Your Ref:
Our Ref: AL/26/08/
Please ask for:
Miss C Forrest

7th April 2008

Outline application for new dwelling alongside 10 Lidsey Road with all matters reserved
10 Lidsey Road Woodgate Aldingbourne

Proposed Site Plan

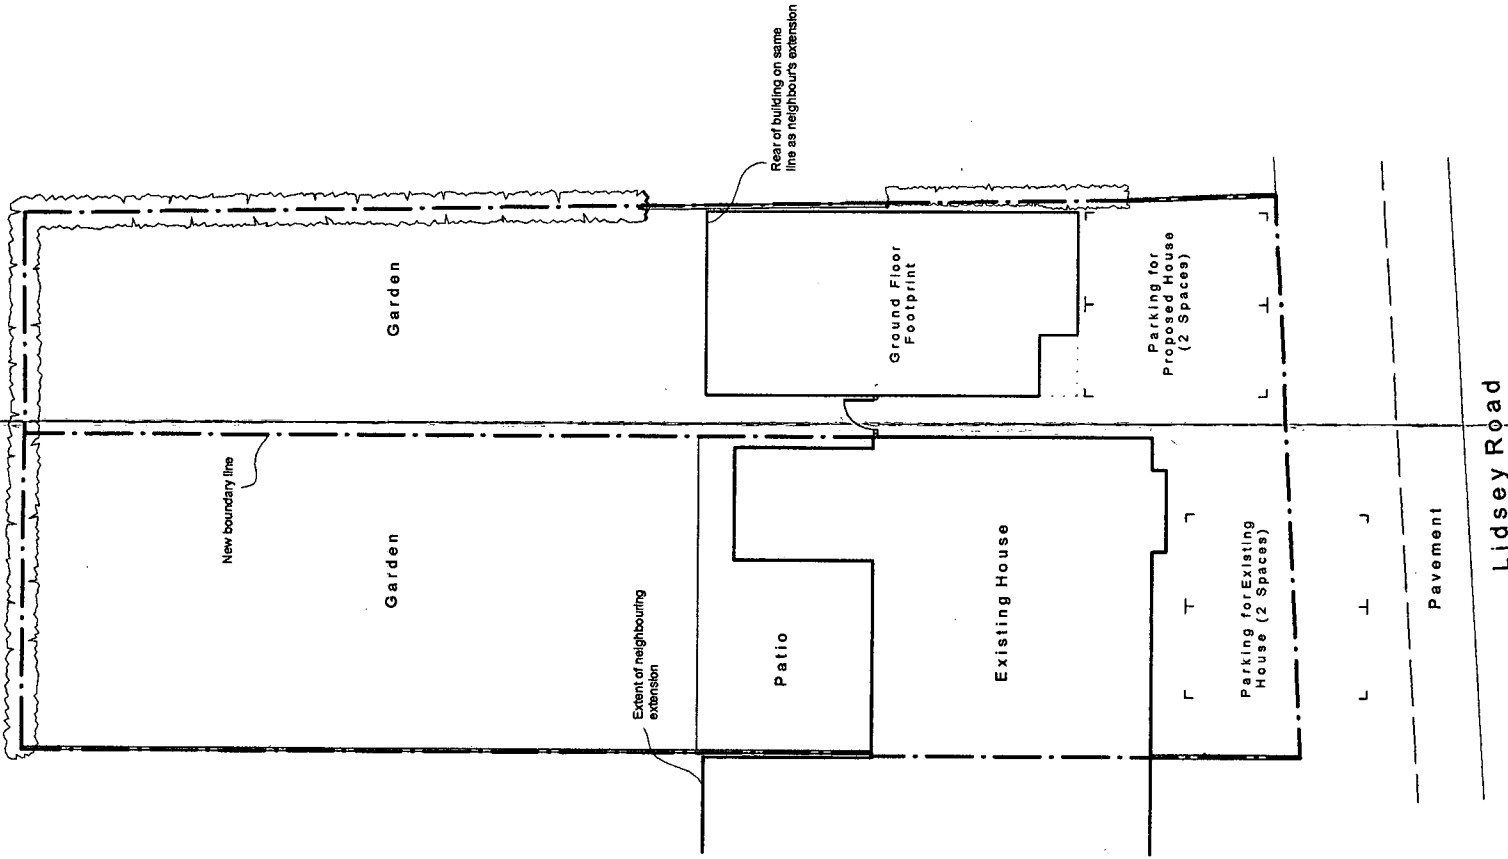
The plot is considered too narrow for another dwelling. □
Limited parking space would result in vehicles reversing onto the A29 to the detriment of highway safety. □
The Parish Council request a site visit before determining this application.
